Your Ref: OWPC16566
Our Ref: BR/305/17/HH 06-11-2017
Please ask for:
Richard Temple

New roof with first floor accomodation & new dormer & new single storey rear extension
30 Mansfield Road Bognor Regis

PROPOSED ROOF PLAN

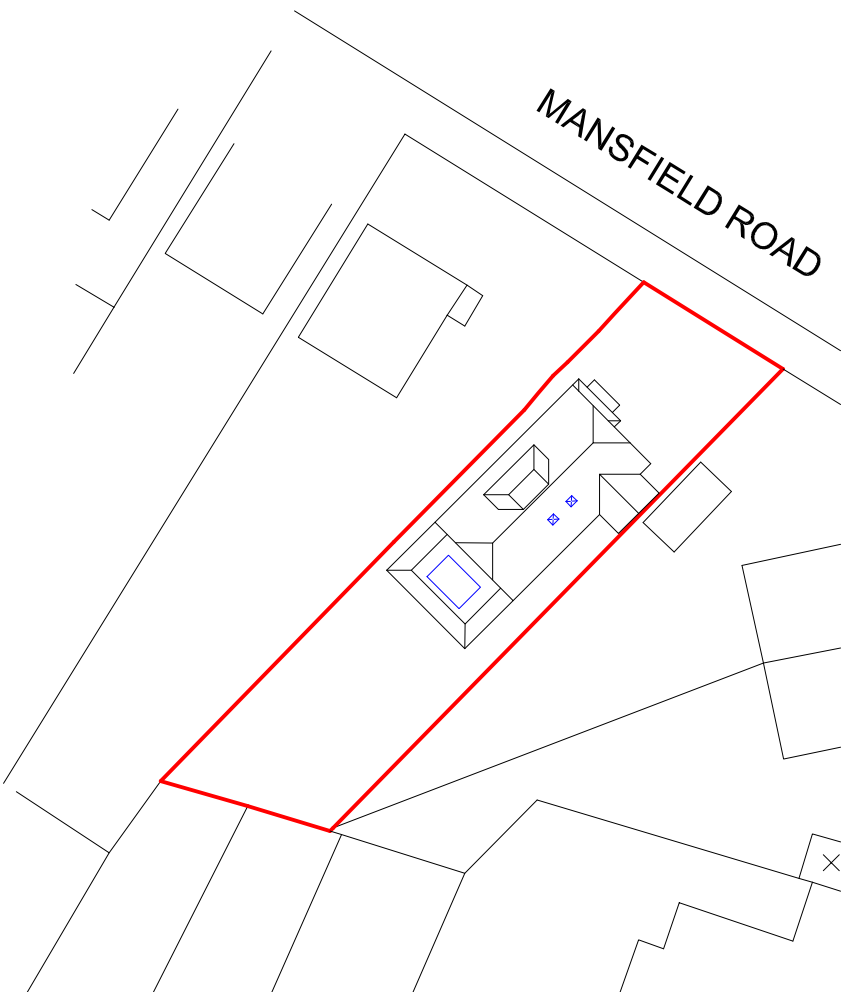
We wish to object to the proposed plans for two dormer windows on the south side of the property.

PROPOSED ELEVATIONS

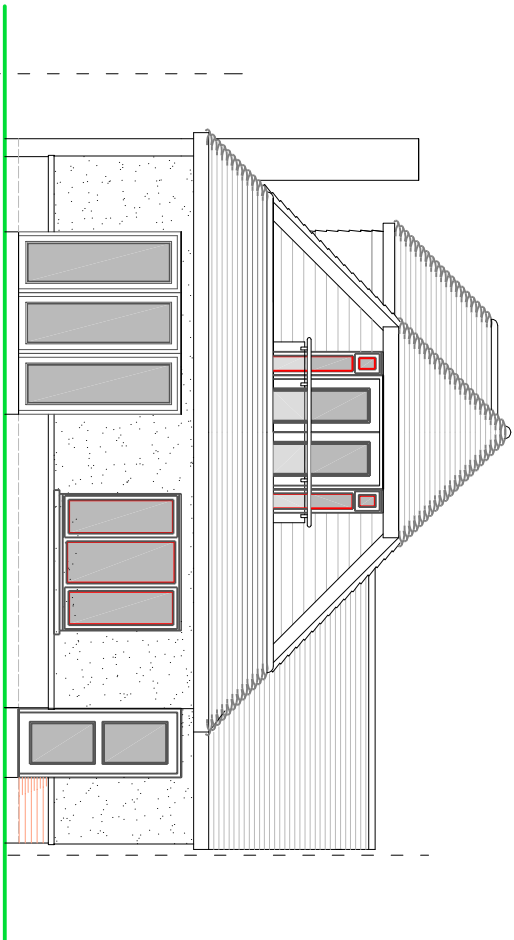
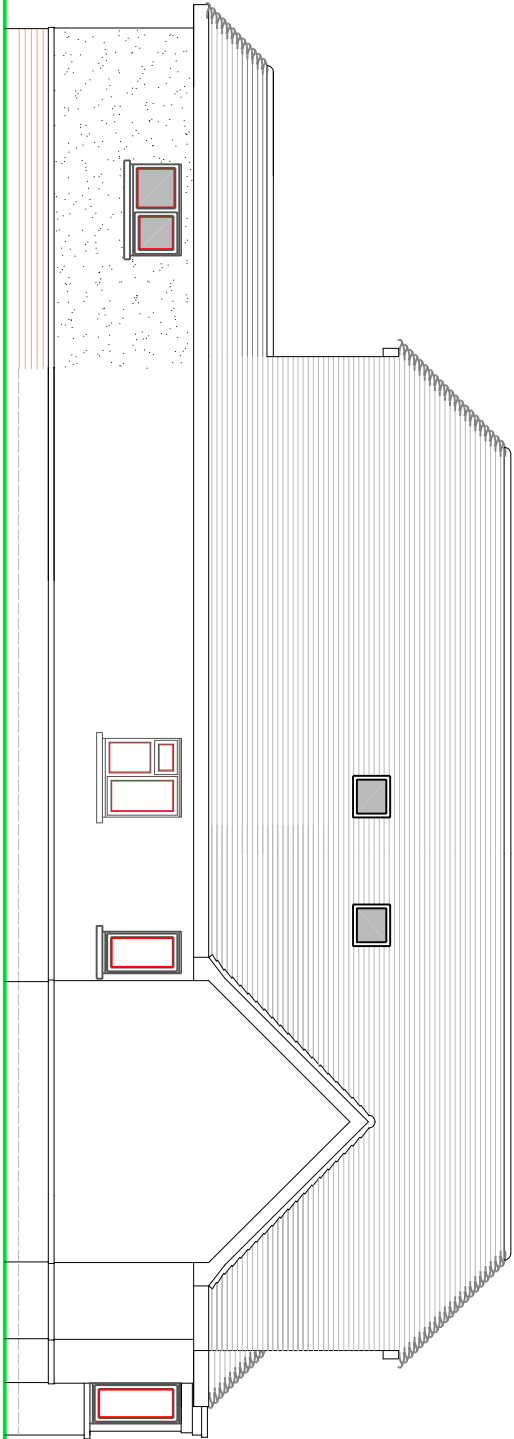
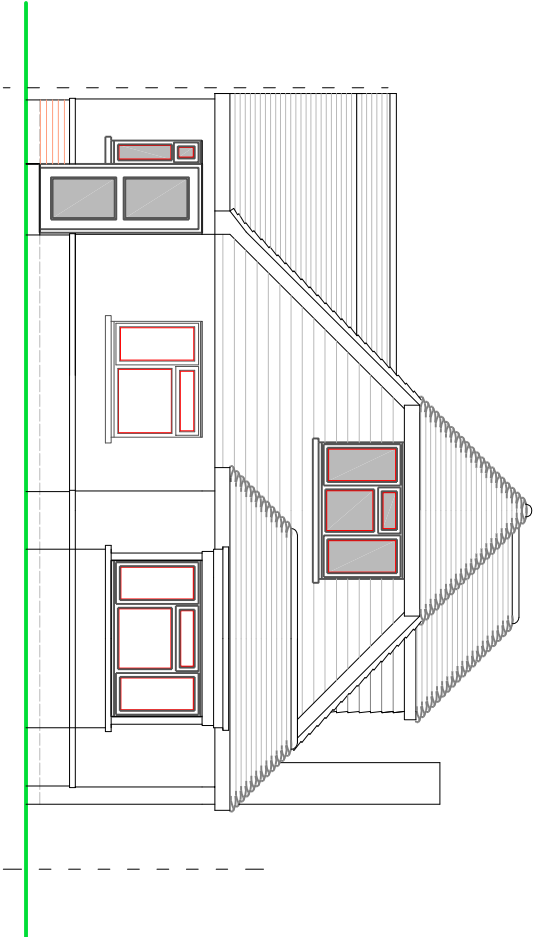
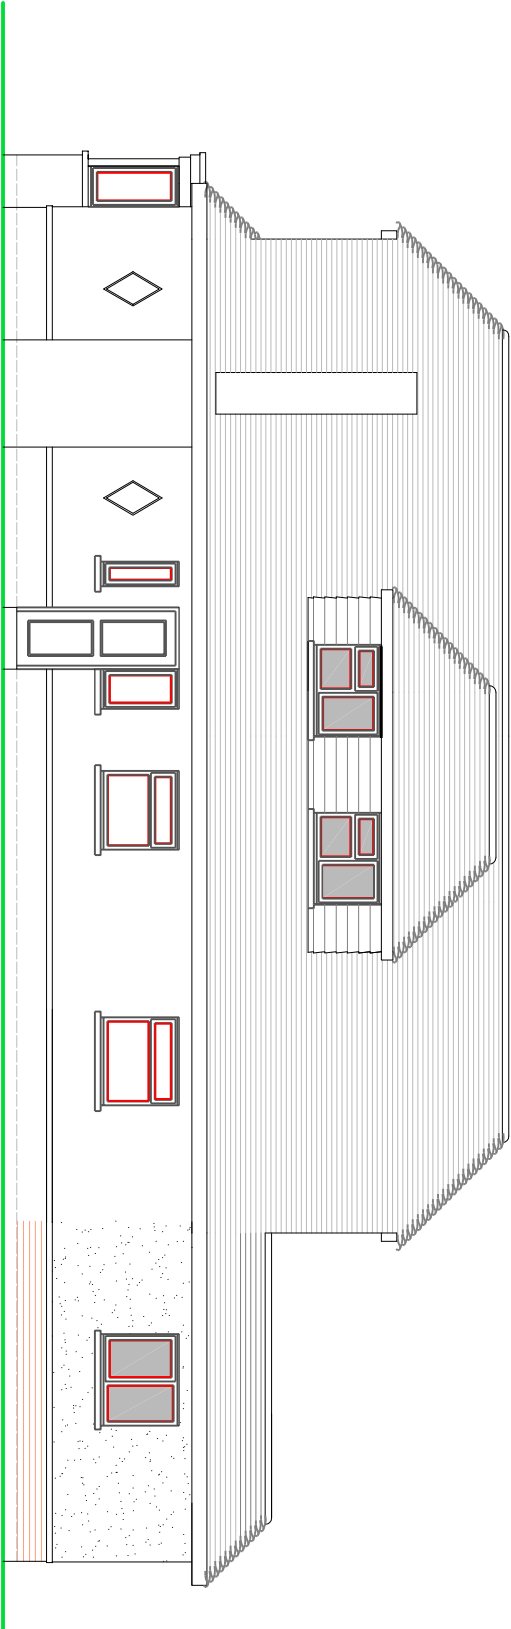
The comments made by Bognor Council that the proposed front dormer development is not in keeping with the surrounding area. We strongly feel that the dormer windows on the south side are also out of keeping to development present in the street scene and would therefore look out of place. These two dormers on the south side are overlooking our property. The works are extensive and alter the existing appearance and design of the bungalow in an adverse way.

We would not object to two velux windows in place of the dormer window provided that they are 1.7 metres from the new floor level to prevent being overlooked and a loss of privacy.
